From: Graham, Laura 
Sent: 29 September 2017 12:35
To: Michael Eastham
Subject: RE: Littlehampton - Fitzalan Link

Environmental Health comment: Further to Persimmon's E Mail dated 14th October 2016. Please would the applicant confirm that the new noise modelling figures provided in respect of the proposed 40 mile per hour link road are anticipated levels at first floor level. Should this be the case then please provide the adjusted noise levels for outdoor living areas at a height of 1.5m above ground level. My comment presumes a pervious road surface. The increased speed may require reassessment of the air quality impact.

Further to our meeting a couple of weeks ago please find attached a report prepared by our noise consultants which compares a change of road surface and speed limits with noise levels.

rev.
P5

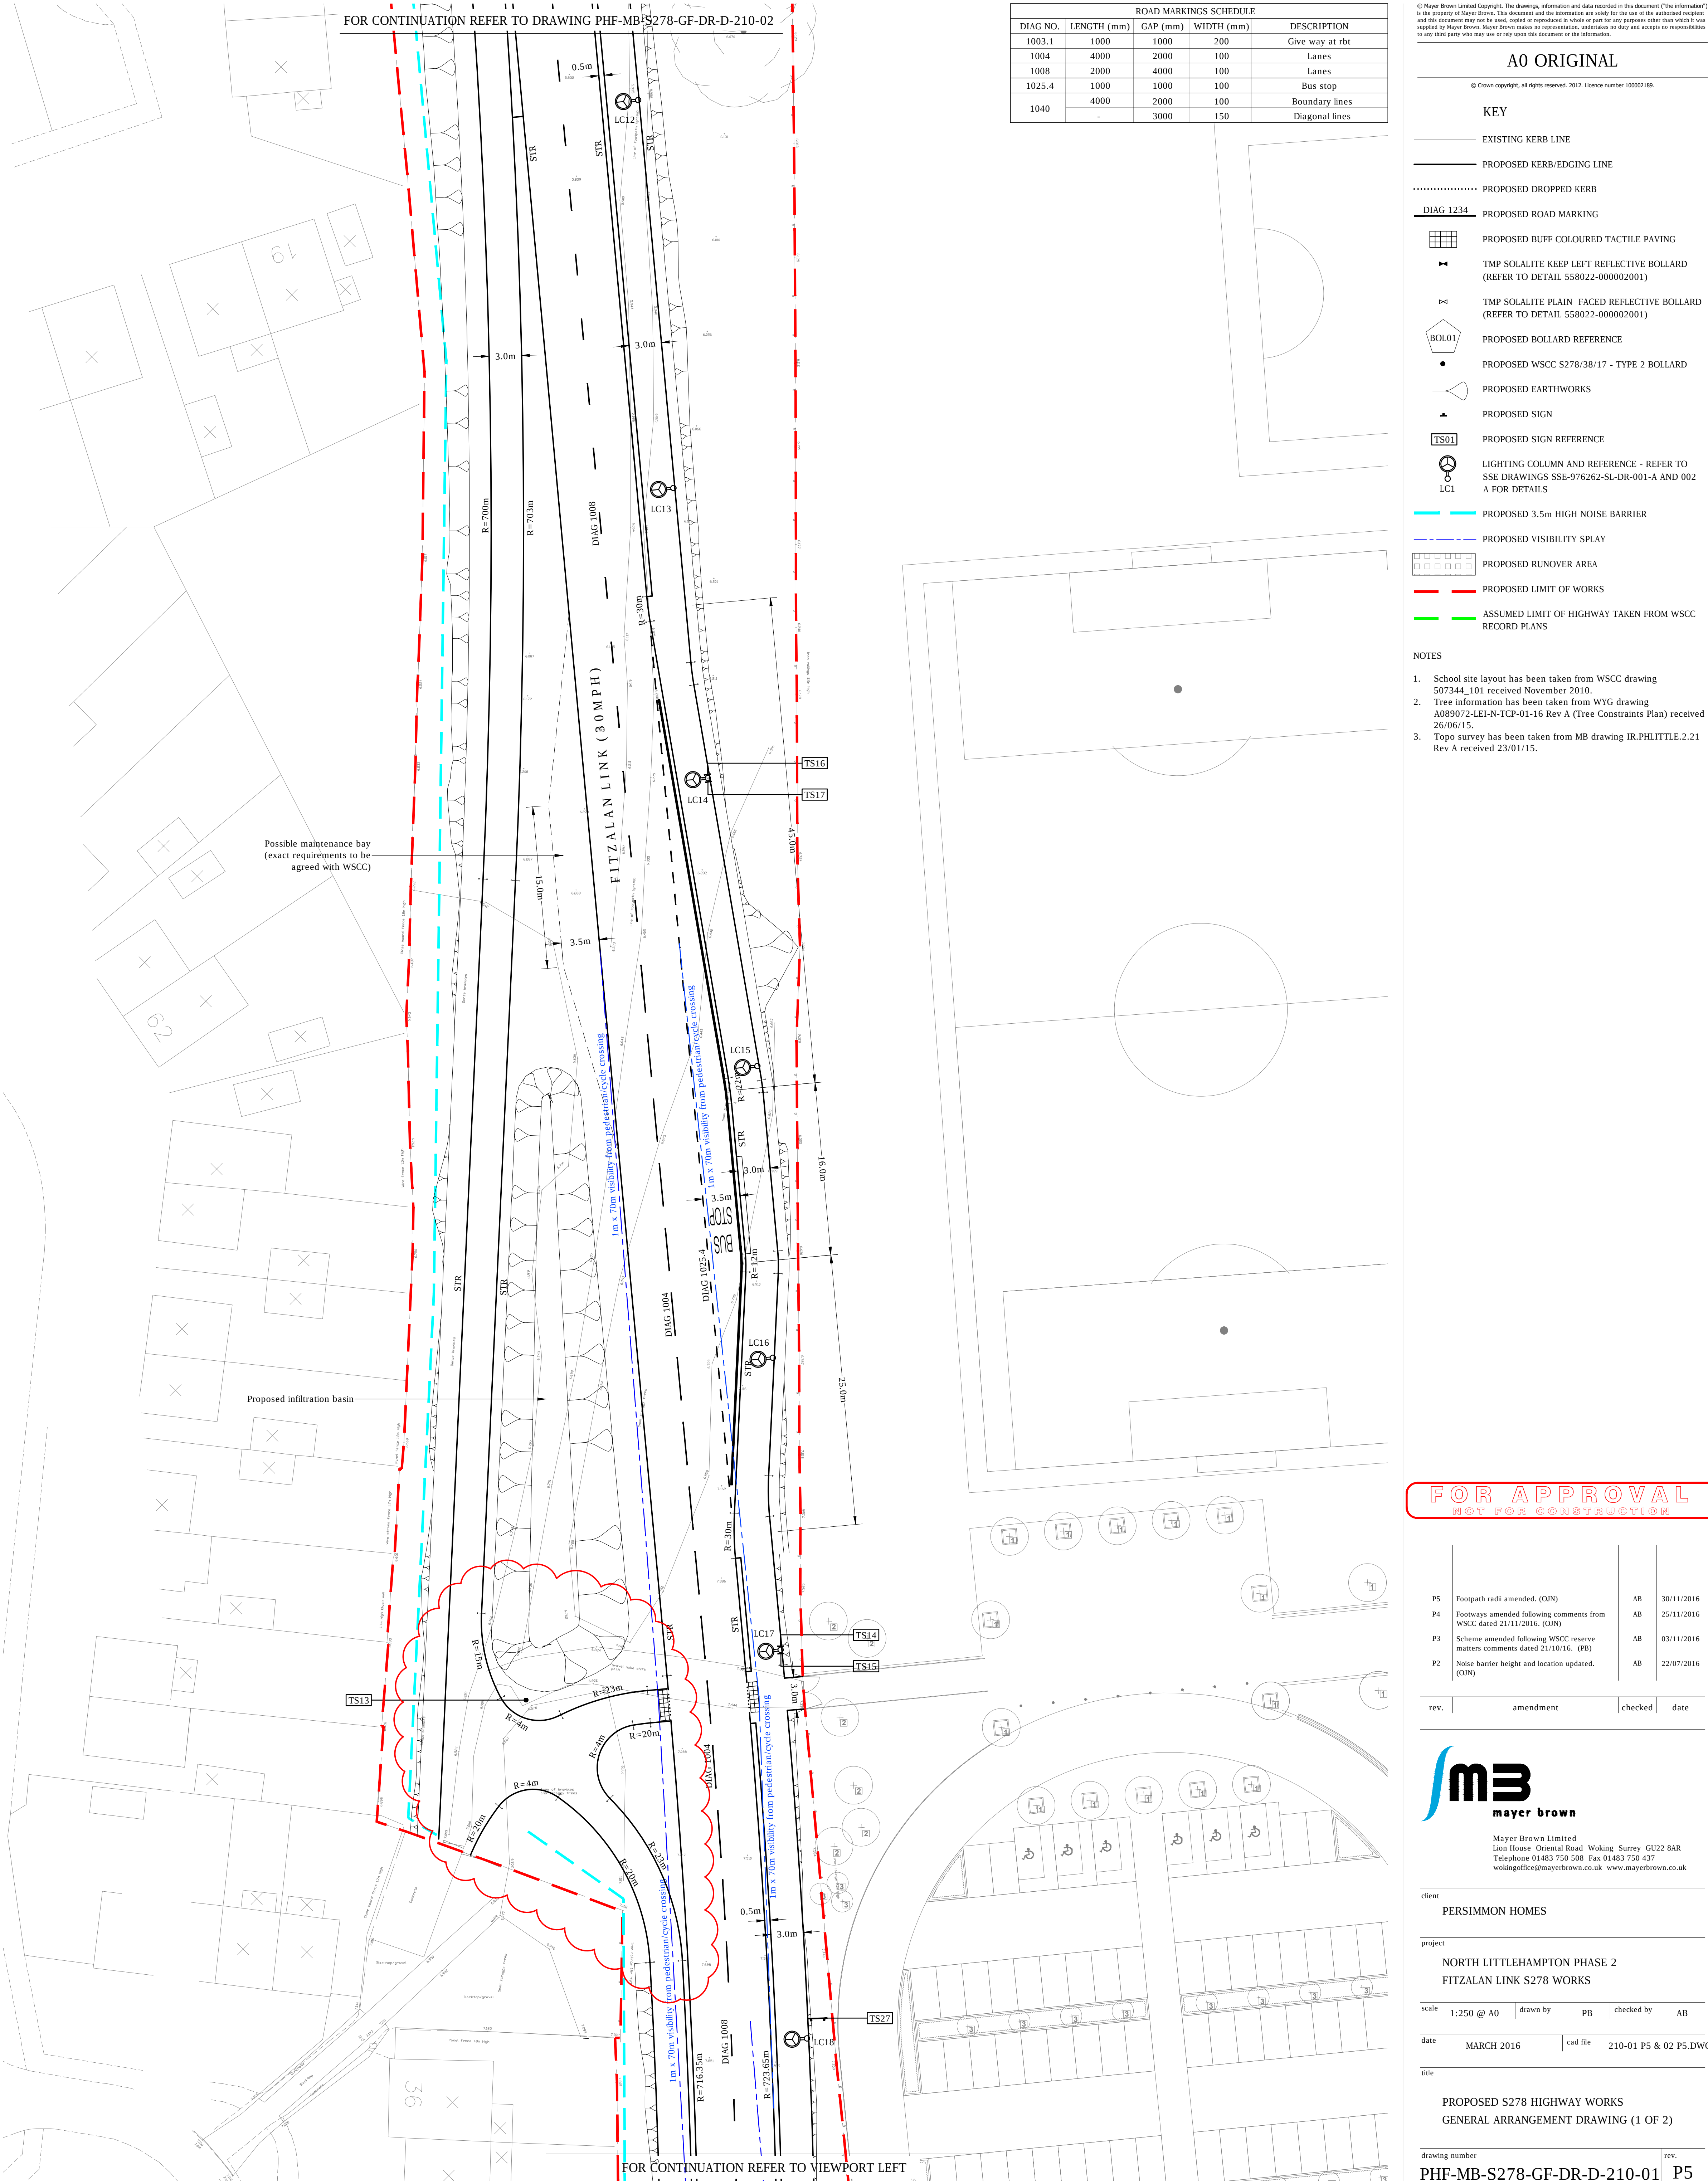
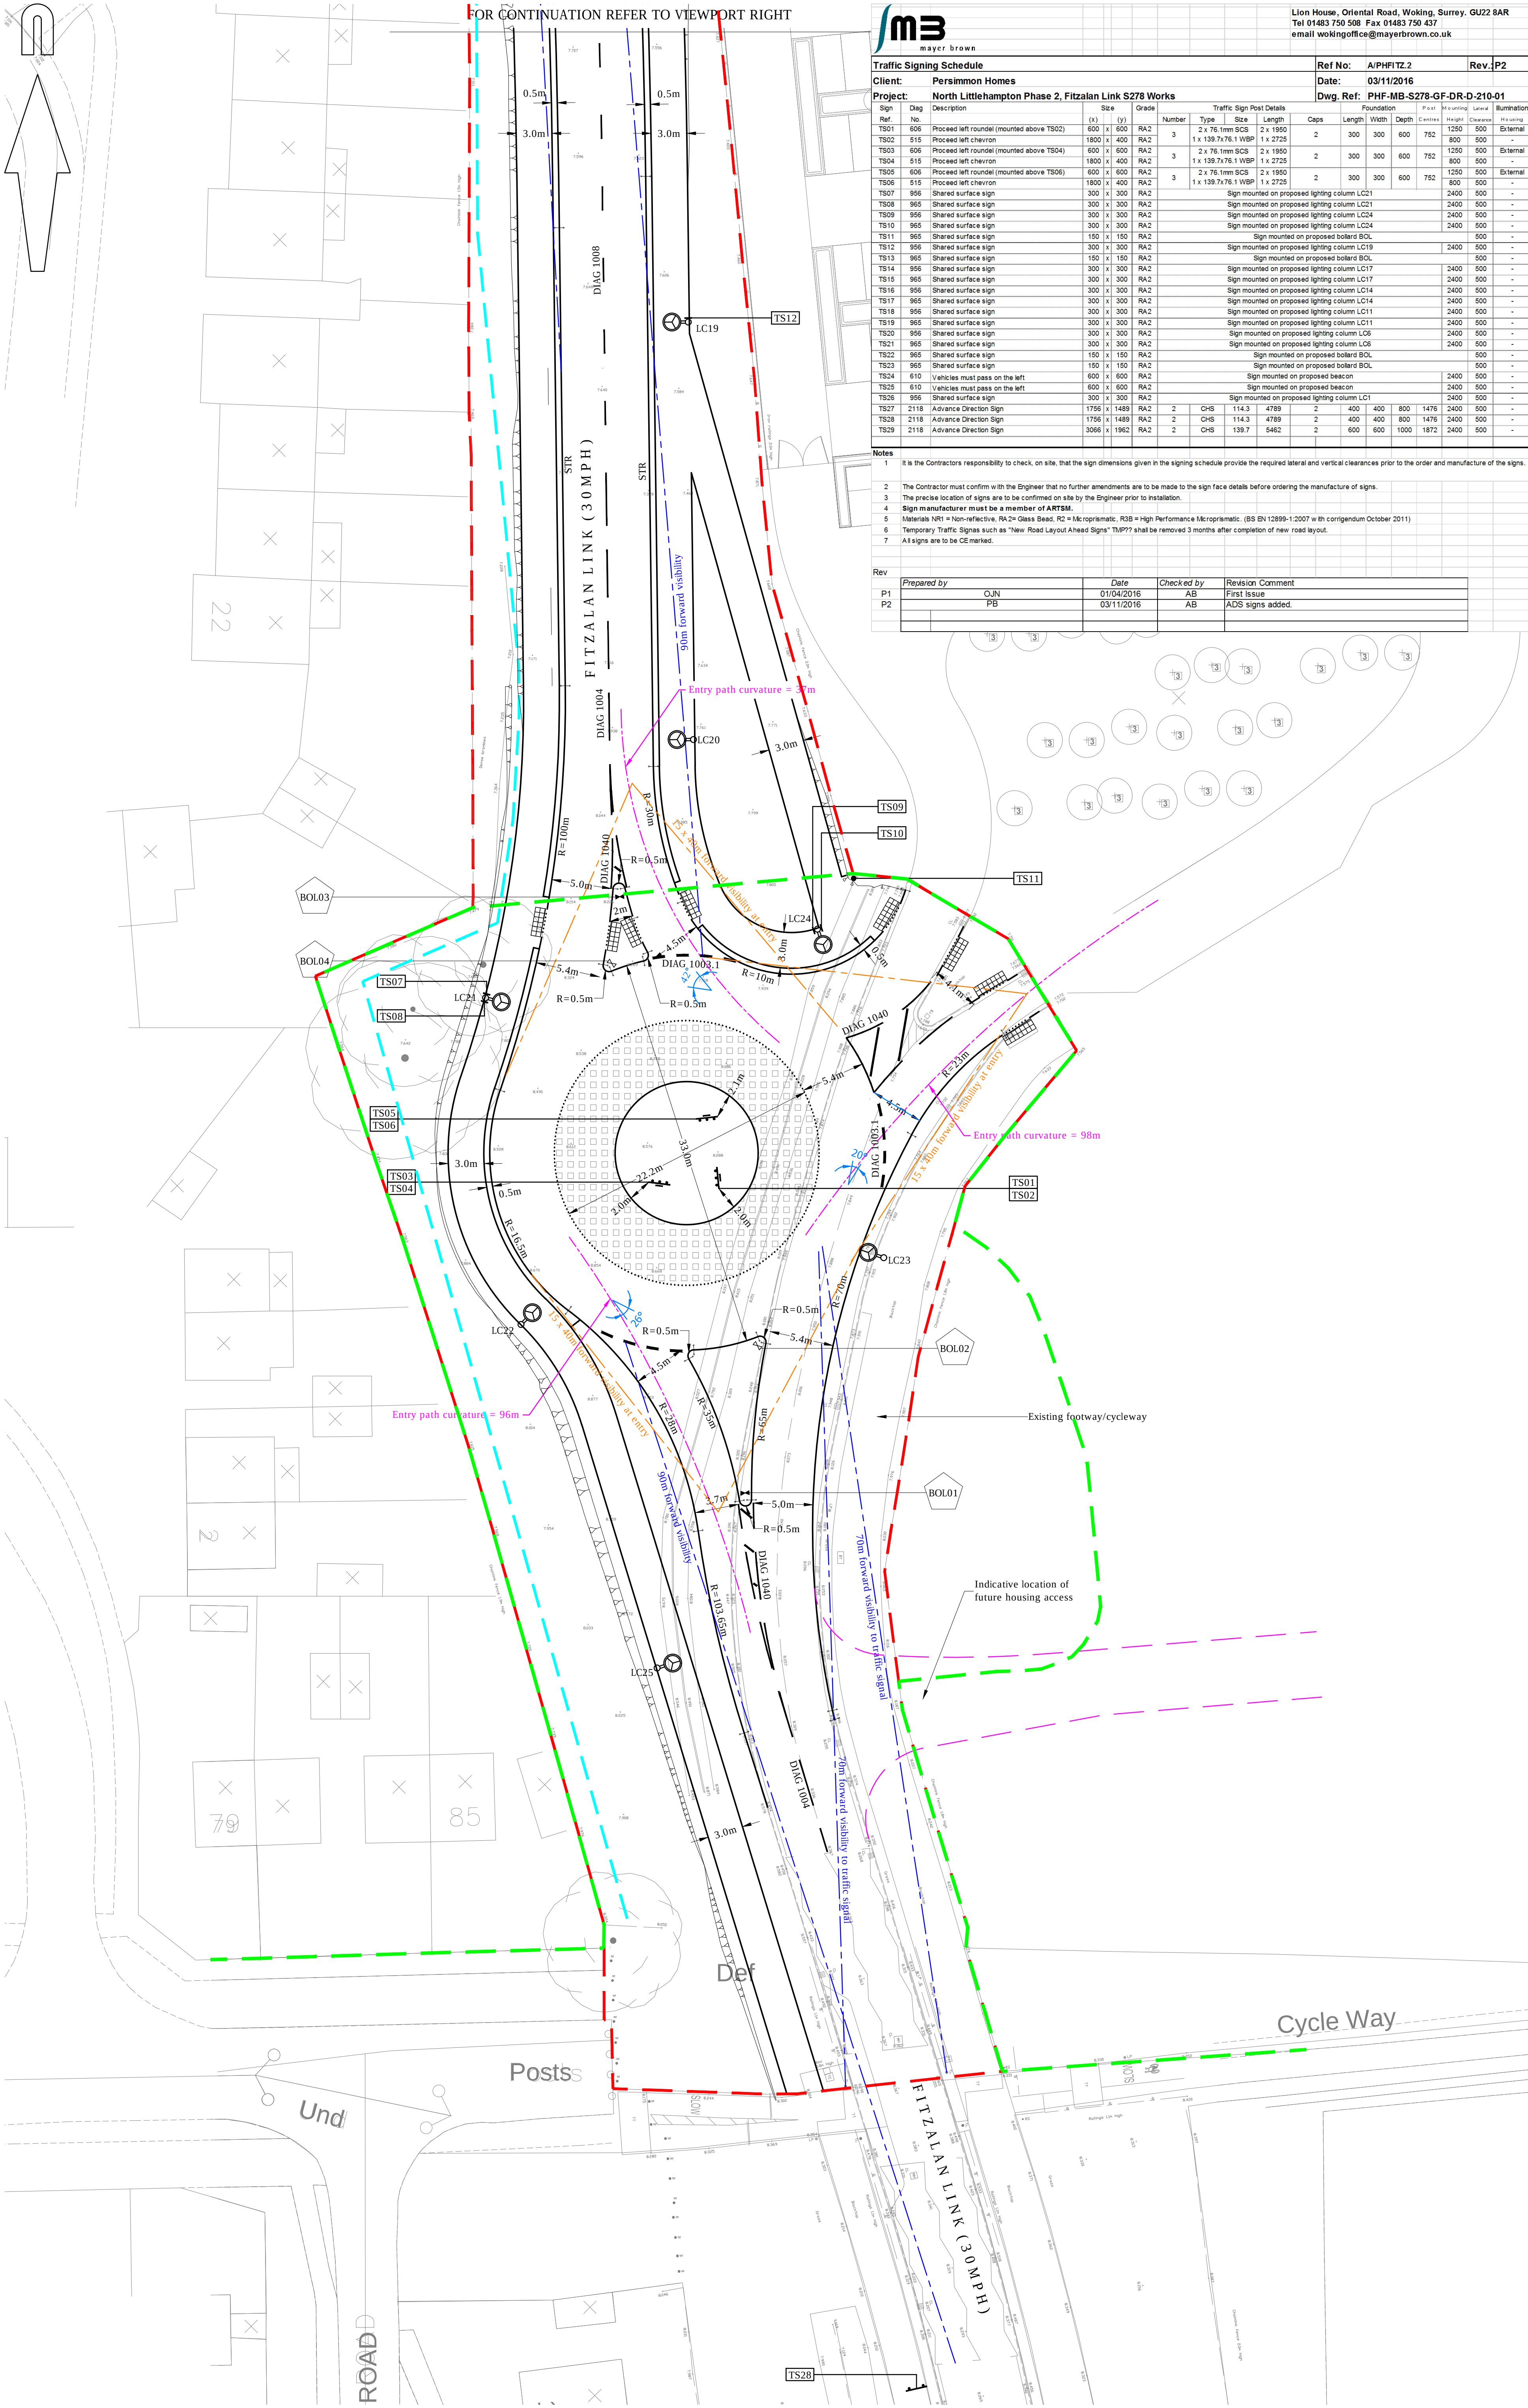
Also, I've spoken to our noise consultant and highway engineer and they can confirm that noise modelling has been undertaken for the whole of the length of the Road include TR39-TR42. In terms of the speed limited, everything south of the proposed speed limit changed is proposed to be 30mph i.e. the signal crossing and roundabout. Hopefully drawings 210-01 P8 (general arrangement drawing 1 of 2) makes this clear.
